From: Lisa Faulkner
Sent: 19 March 2018 14:03
To: 'Simon.Davis@arun.gov.uk'
Subject: Application_Ref_No=BE/17/18/PL

Having viewed the above planning application on line I would like to raise my concerns/objections to the application as follows:

PROJECT	Proposed Bungalow 37 Norbren Avenue, Bognor Regis		
TITLE	Proposed Ground and First Floor Plans		
CLIENT	Mr & Mrs Clarke		
SCALE	1: 100	DATE	16/09/2017
DRAWING NO.	906-01	rev.	.

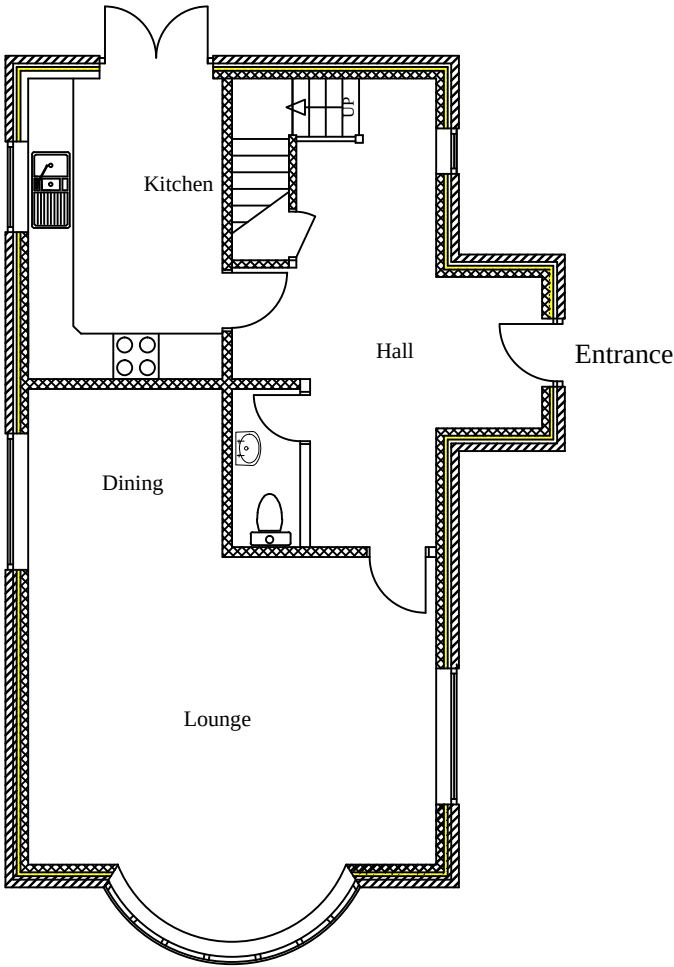
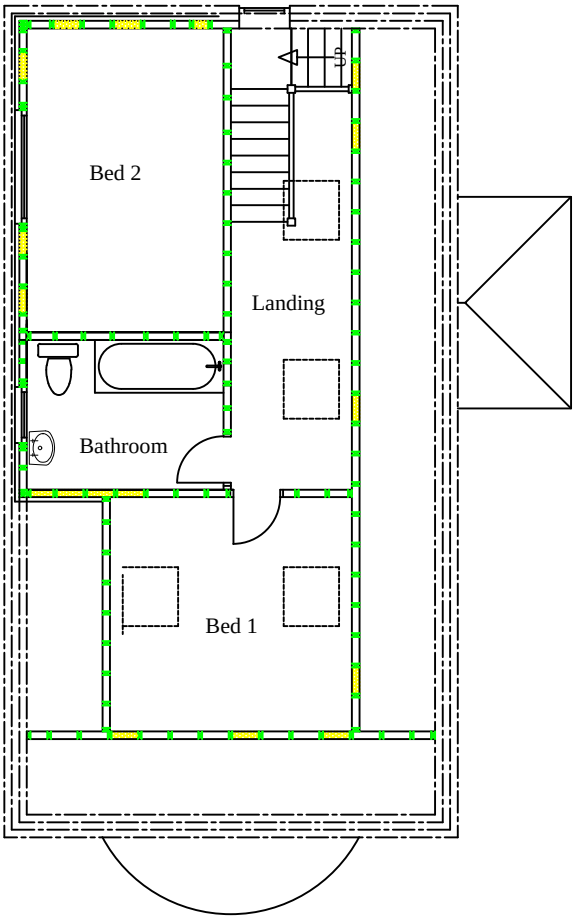
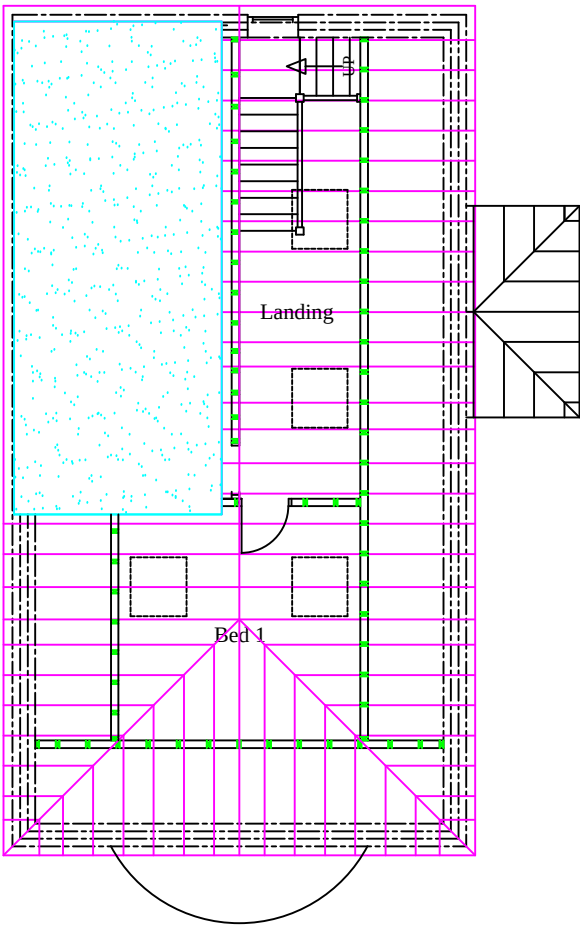
The proposed building will be overlooked by two neighbouring properties which will have an impact on the standard of natural daylight on elevations, the outlook (view) and privacy of the proposed development and existing properties will be poor, due to the 'overcrowding' of the site, it is noted that the developer plans to construct the building in existing garden space.

The proposal increases population density by creating possible sub-division of curtilages and displacing garden space, resulting in an over developed site, which is completely out of character for Norbren Avenue and Green Court Drive.

Soft landscaping, in the form of hedging and a tree will be lost on the boundary that forms the corner of Green Court Drive and Norbren Avenue which affects the quality of the residential environment.

Farhad Aarabi	
PROJECT	Proposed Bungalow 37 Norbren Avenue, Bognor Regis
TITLE	Proposed Elevations
CLIENT	Mr & Mrs Clarke
SCALE	1: 100
DRAWING NO.	906-02
DATE	16/09/2017
rev.

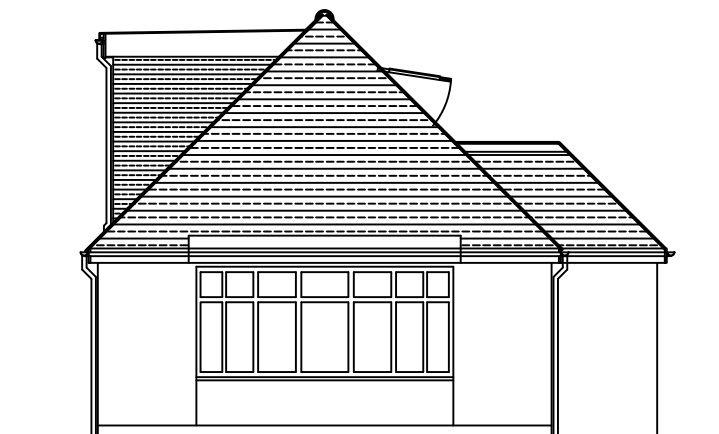
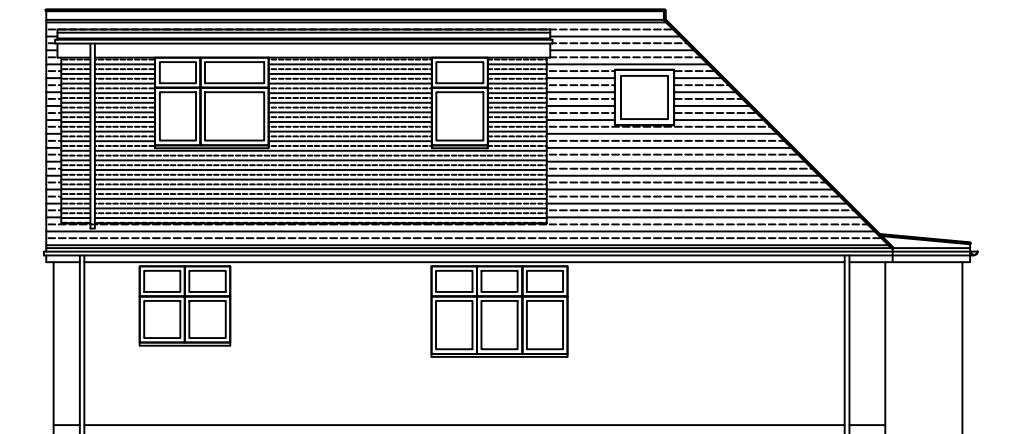
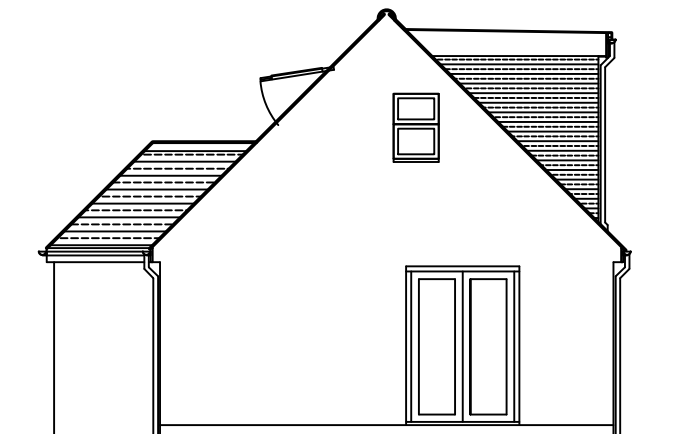
This proposed building does not show any regard for the local character, design and scale of buildings that surround it. The existing buildings in Norbren Avenue and the surrounding area are of a two storey construction, built to a late 1930s construction type with projecting bay windows. The proposal is for a bungalow, which is lower than the current site lines of the existing building and this will have an adverse visual impact in contrast to other buildings in the Road.
